99 Fifth Avenue Ottawa Urban Design Review Panel Resubmission Presentation
Formal Review

T h u r s d a y , M a y 3 , 2 0 1 8

Urban Design Review Panel Recommendations, January 11, 2018

drawn by  
**AS/AK** checked by  
**PJ**

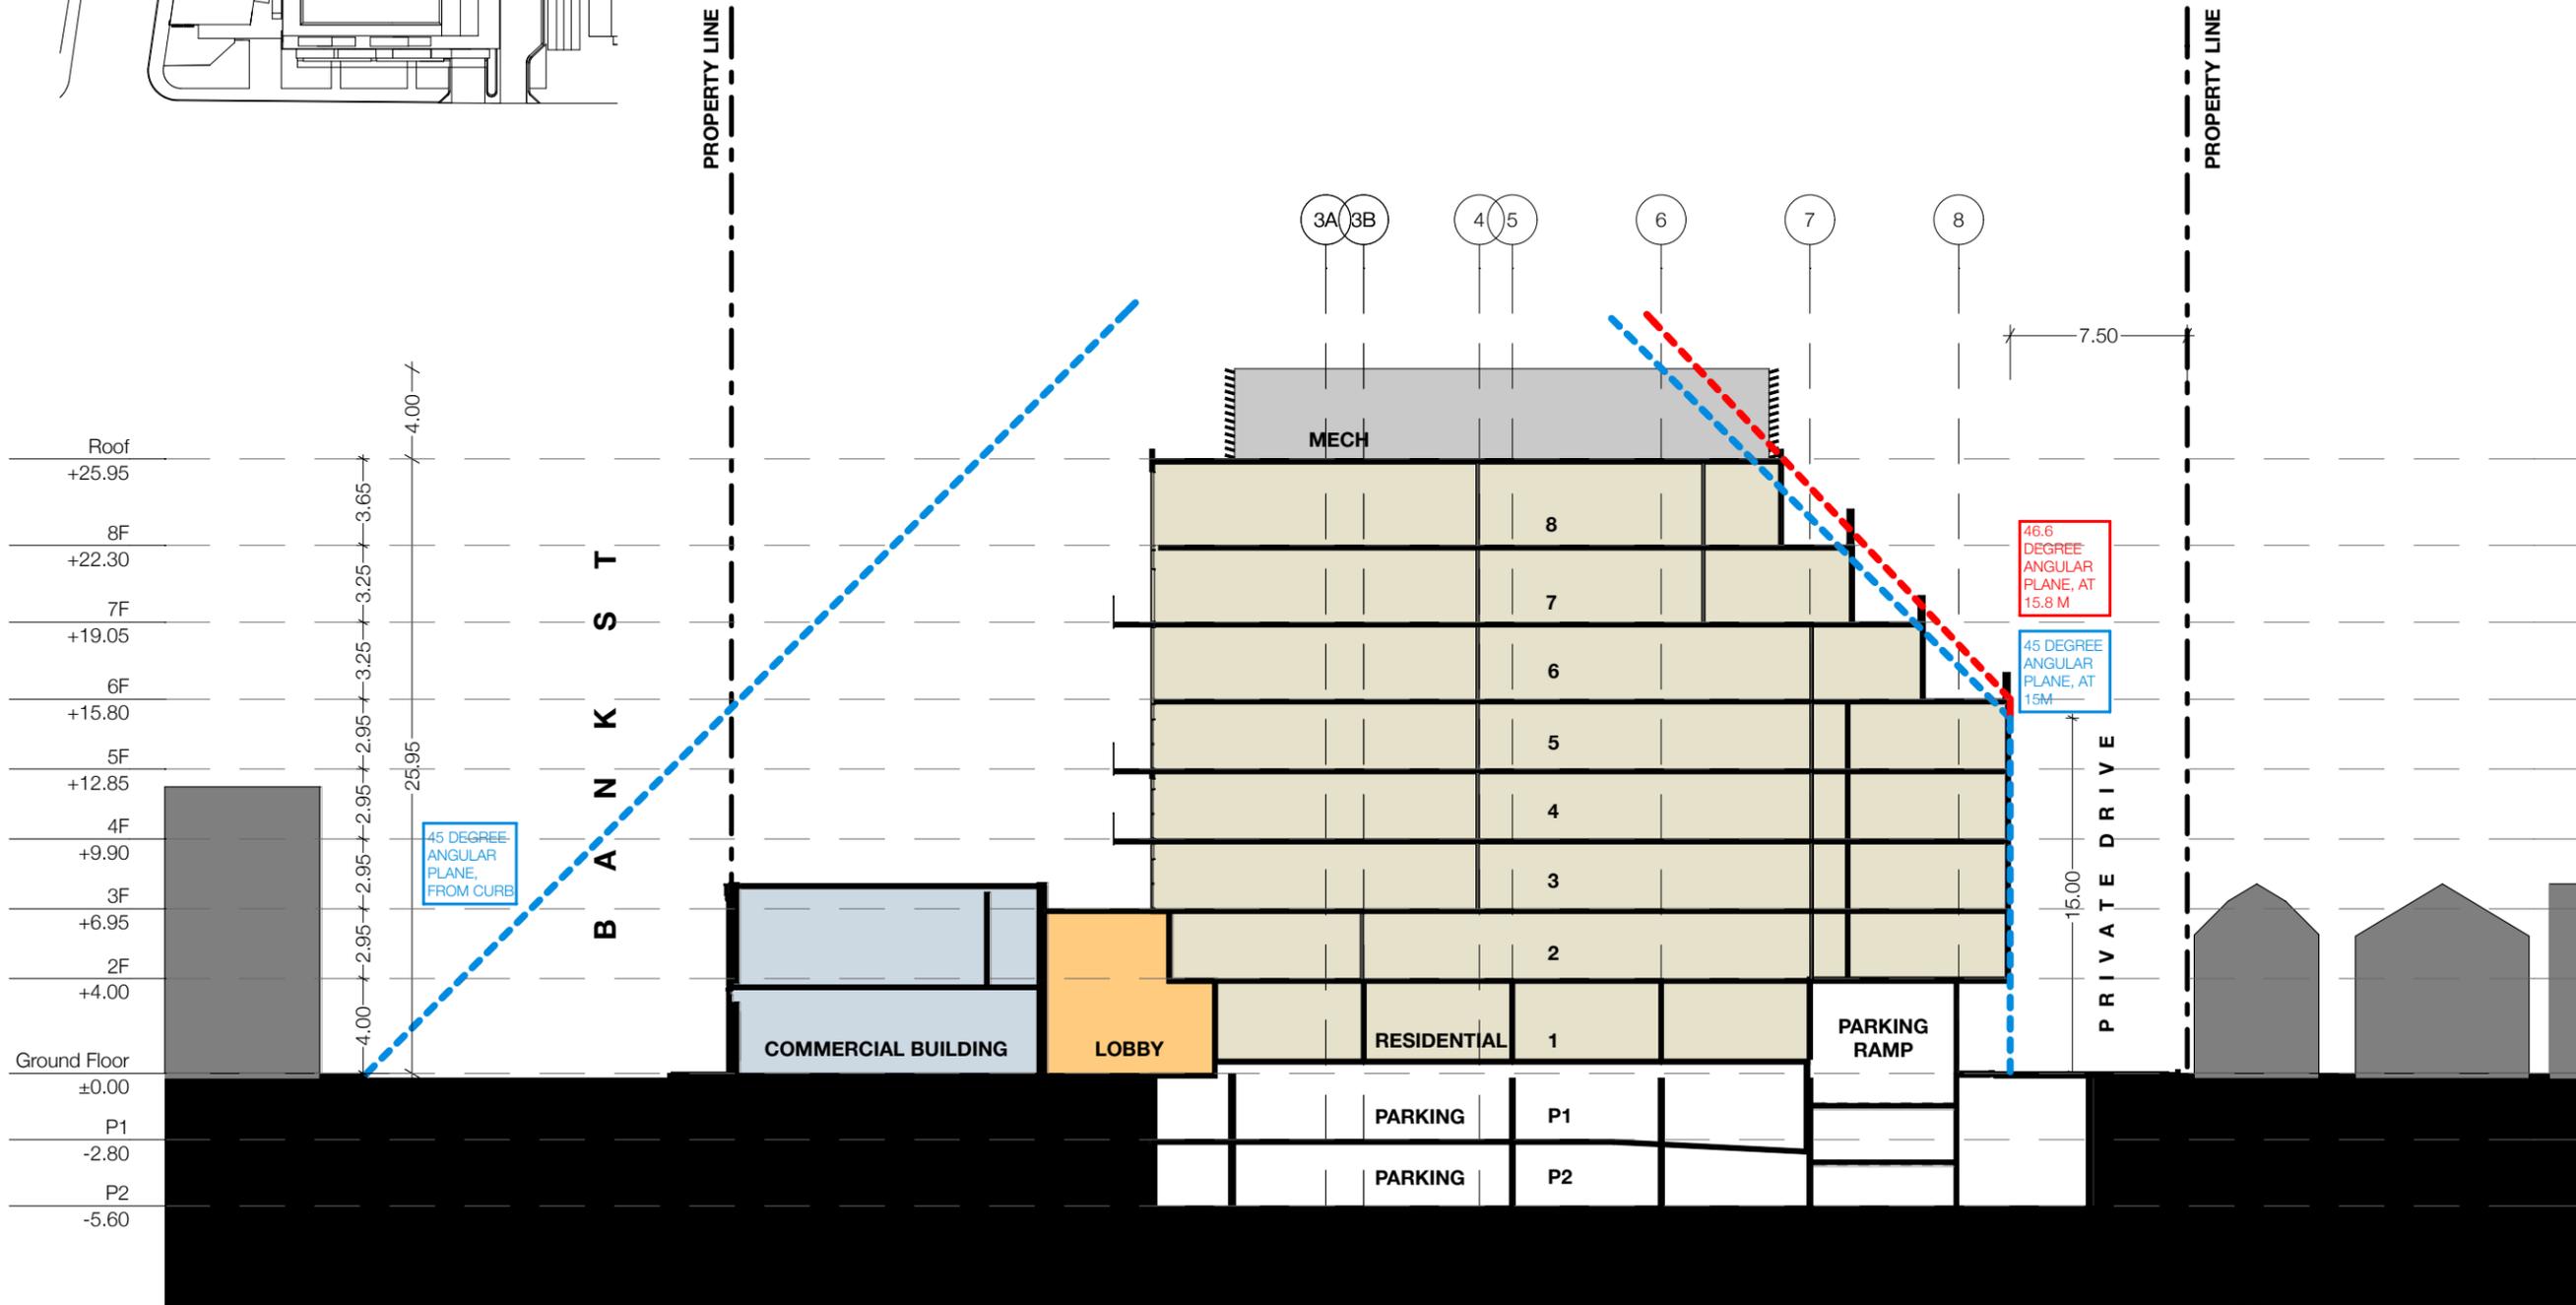
4 Establish a two storey datum line across both Fourth and Fifth Avenue facades that align with the houses in the existing area	A datum line was created and is consistent with the existing residential buildings. It is the average height of the houses along Fourth and Fifth Avenues. The floors above the second / third storeys are set back generally keeping with the fronts of the houses to the east.
5 Upper storeys above datum line should be recessed	The floors above the second / third storeys have been set back.
6 Concern with the contrast of the massing at the Northwest corner	A commercial lobby has been placed at the northwest corner of the building, creating an inset space breaking up the corner into smaller forms.
7 Balconies are distracting. Try and integrate them, making vertical bands more prominent, and establishing a simplified vertical alignment on north and south facades	All projecting balconies along Fourth and Fifth Avenues have been removed and integrated into the façade of the building. The massing along Bank Street has been simplified in keeping with the revised design.
